OXFORDSHIRE COUNTY COUNCIL'S RESPONSE TO CONSULTATION ON THE FOLLOWING DEVELOPMENT PROPOSAL

Application no: 17/00559/F

Proposal: Variation of conditions 1, 2, 3, 5, 7, 9 and 21 of 14/02067/OUT to enable proper phasing of the development

Location: Land East Of Evenlode Crescent And South Of Langford Lane, Kidlington.

Oxford Technology Park
Phasing Plan

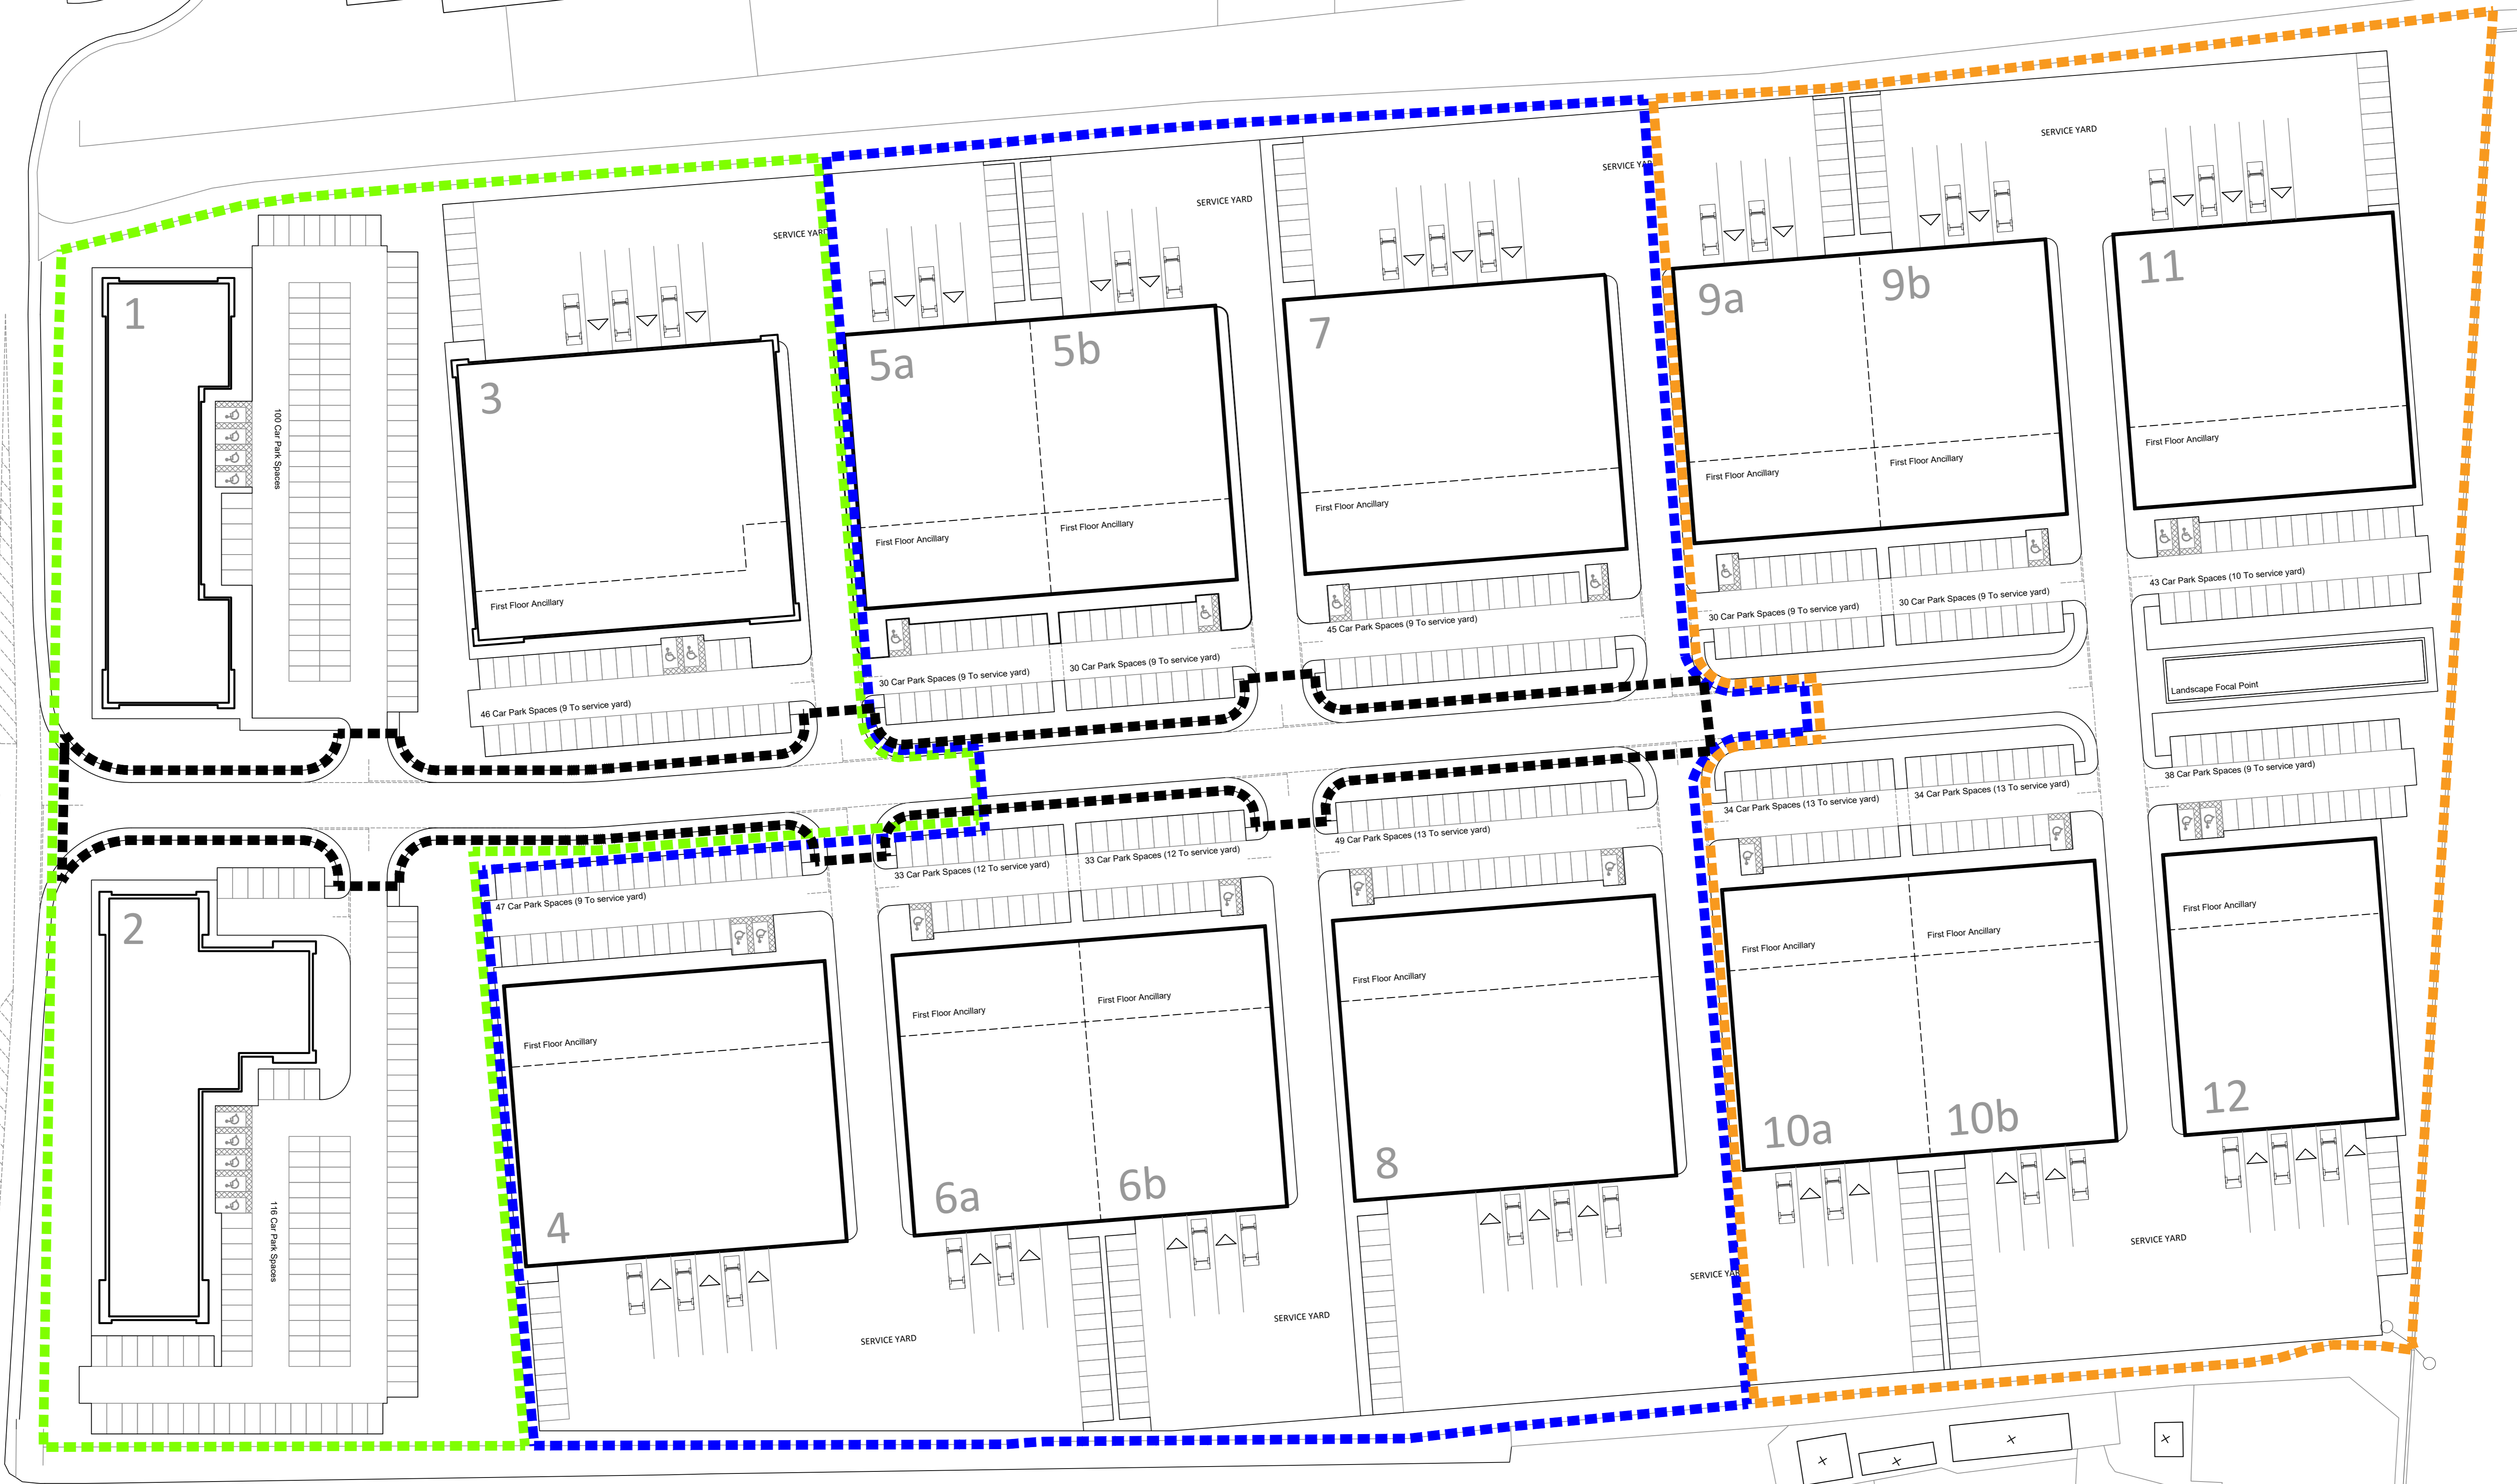
A phasing plan has previously been submitted to discharge Condition 5. This followed the indicative layout and clearly shows that some units share accesses and service yards. The boundaries between phases cut across some of these sharing arrangements. Therefore it would not be possible to determine whether the access, circulation and surface water drainage for each phase was acceptable in isolation.

If a phasing plan were to be agreed and added to the list of approved plans and documents in Phase 4, and this phasing plan had very distinct phases that were not interdependent in the way described above, then it might be possible to agree that conditions 1, 7, 9 and 10 could be varied as proposed.
